**From:** [Planning](#)  
**Cc:** [Emily Stainer](#)  
**Subject:** URGENT regarding 6/2020/1365/FULL  
**Date:** 06 October 2020 14:40:07  
**Attachments:** [eNeigh](#) [pdf](#)  
**Importance:** High

The site plan for No 34 Vineyards Road shows a number of bushes and trees to be planted along the boundary with No 32. Our insurance company had requested all trees and bushes to be removed along this boundary as their roots had caused subsidence to our flank wall. Specifically, No. 34 were instructed by the insurance company dealing with our claim to clear all bushes along the boundary line with our flank wall and also specified that there had to be a minimum clearance of 3.5m to our property of bushes.

Site Plan 1:200

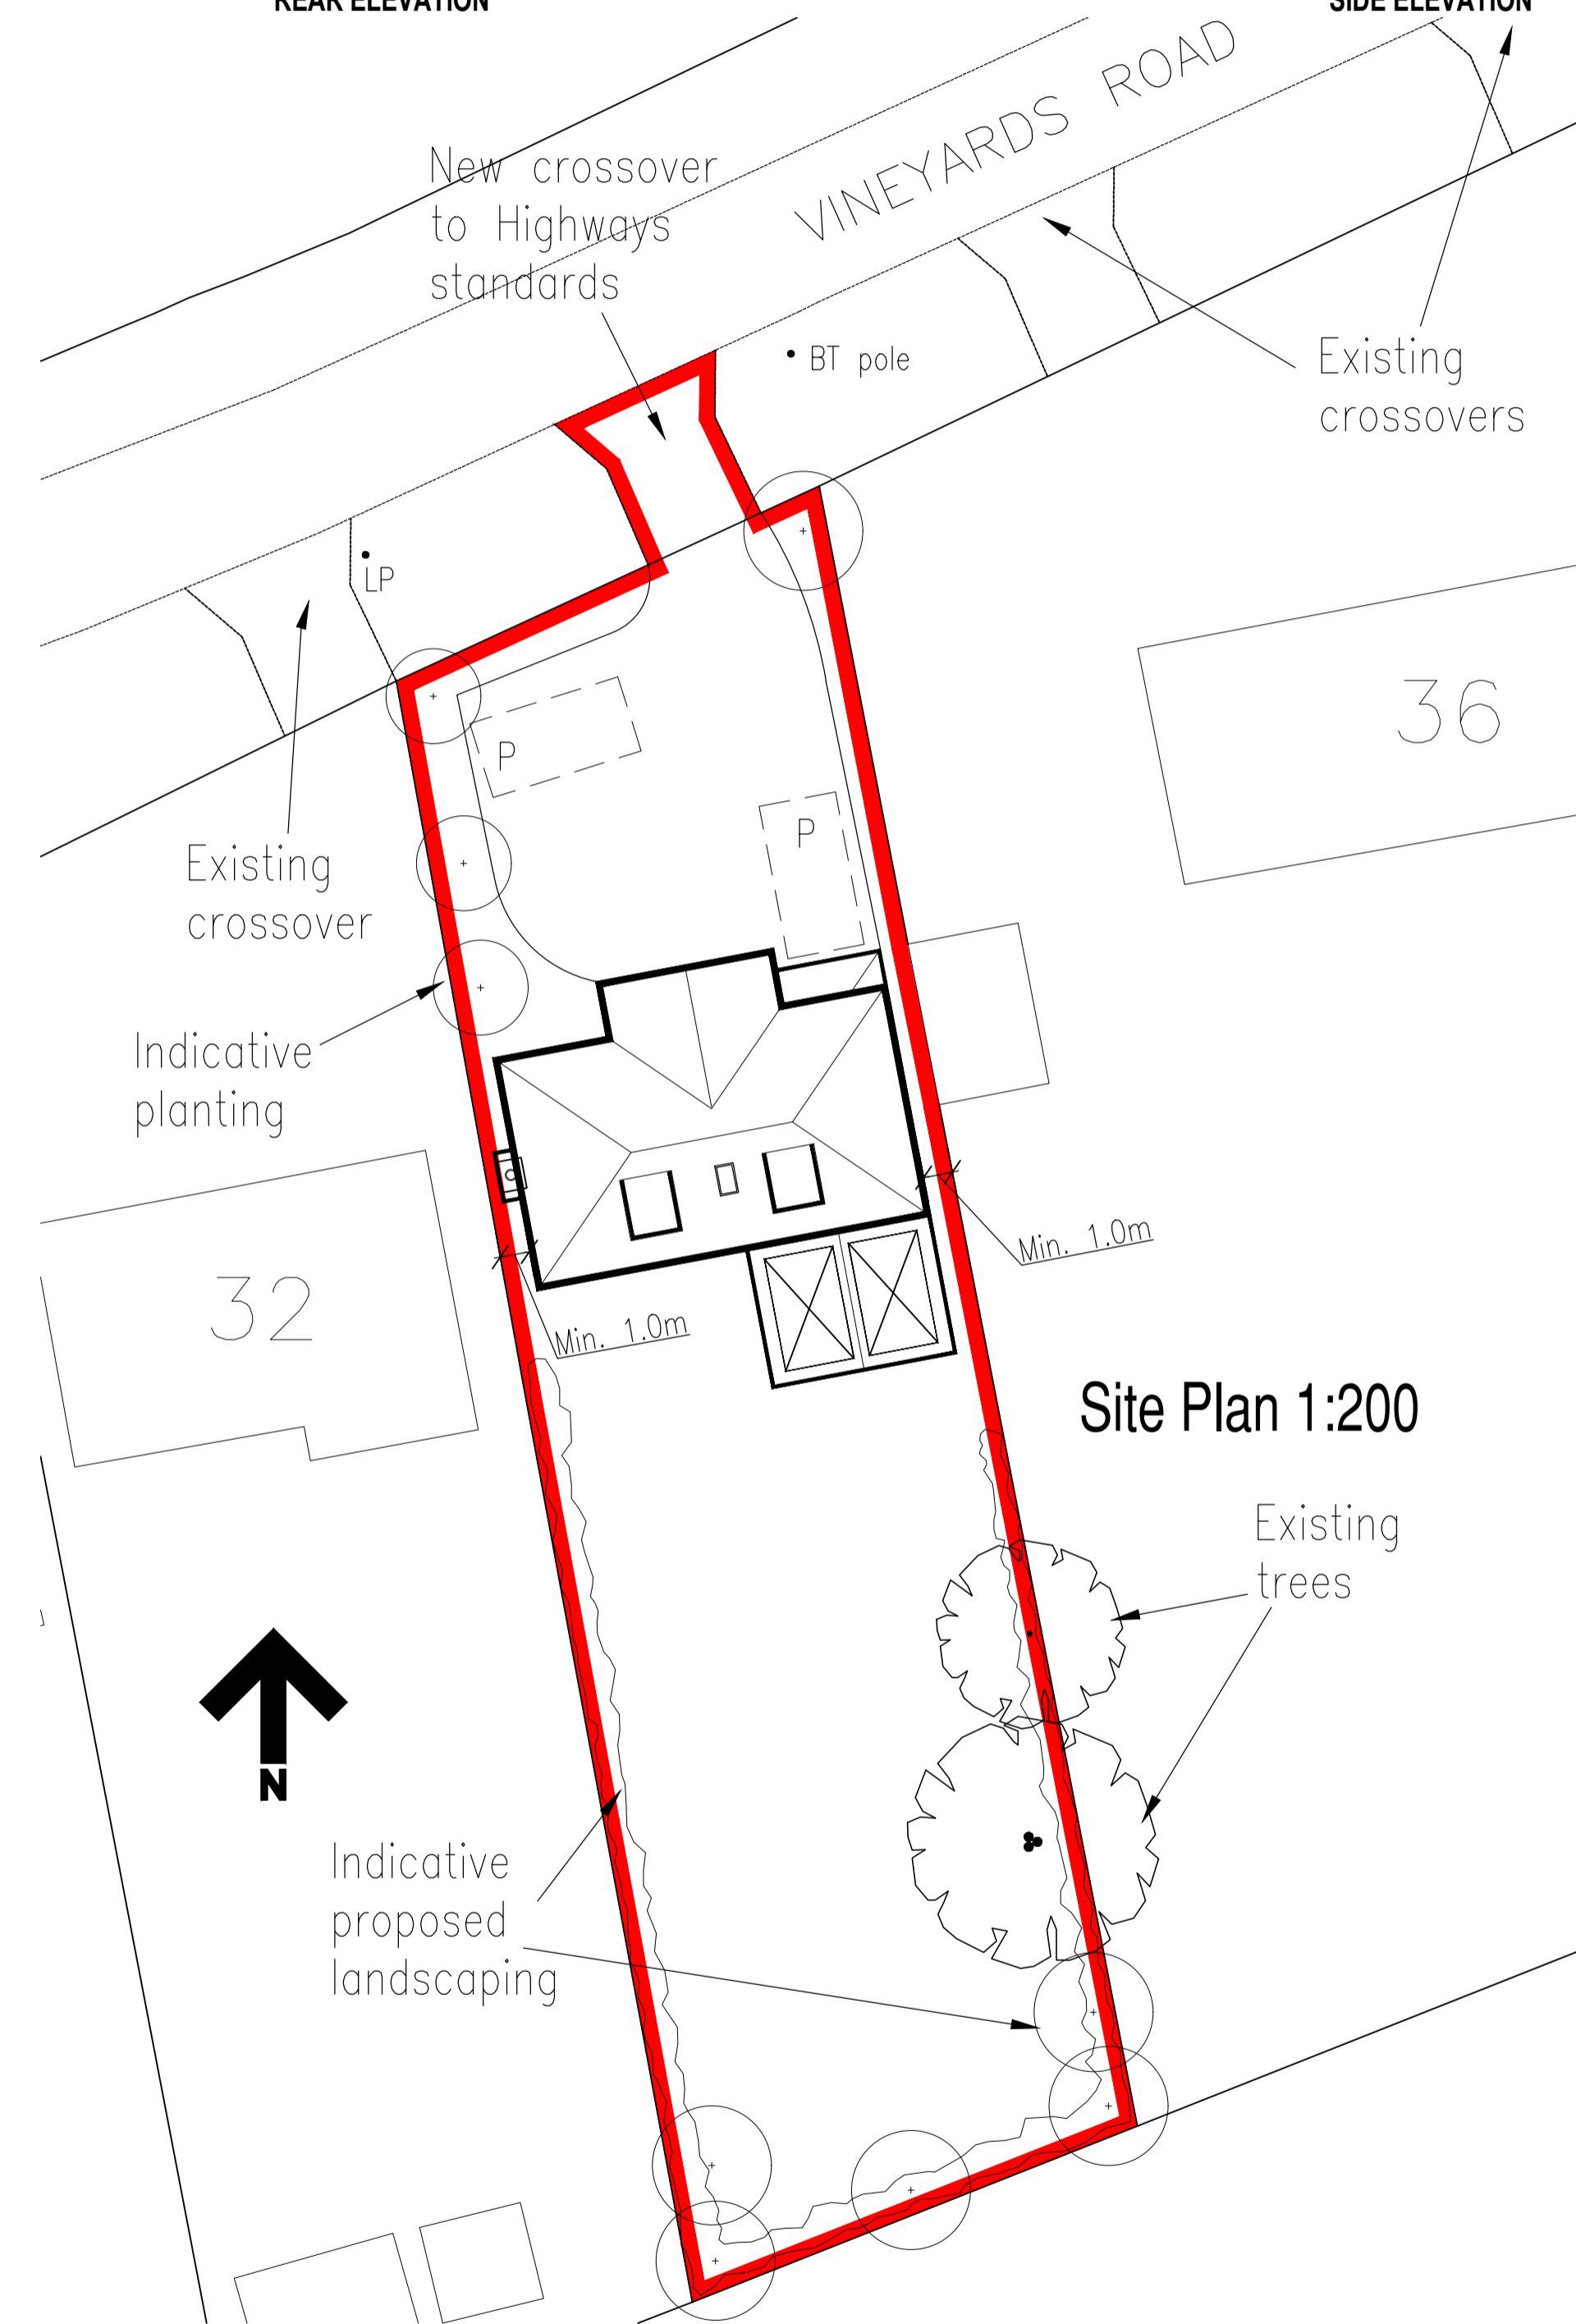
As for the planting of trees, they were instructed to be removed from along the boundary line and up to the street level. So therefore, what is being proposed contravenes these requirements from the insurance company. The landowner of No.34 is aware of all these instruction and requirements as they were conveyed to them. We are gravely concerned that if these requirements are ignored and trees /bushes are allowed to be planted within these distances it will further compromise our houses structural integrity in the future. For this reason, we urge you not to allow or permit in any way the planting of these types of vegetation in these areas as specified in this letter. This should be taken into serious consideration as it's not fair to risk further damage to our house so a new property can be built.
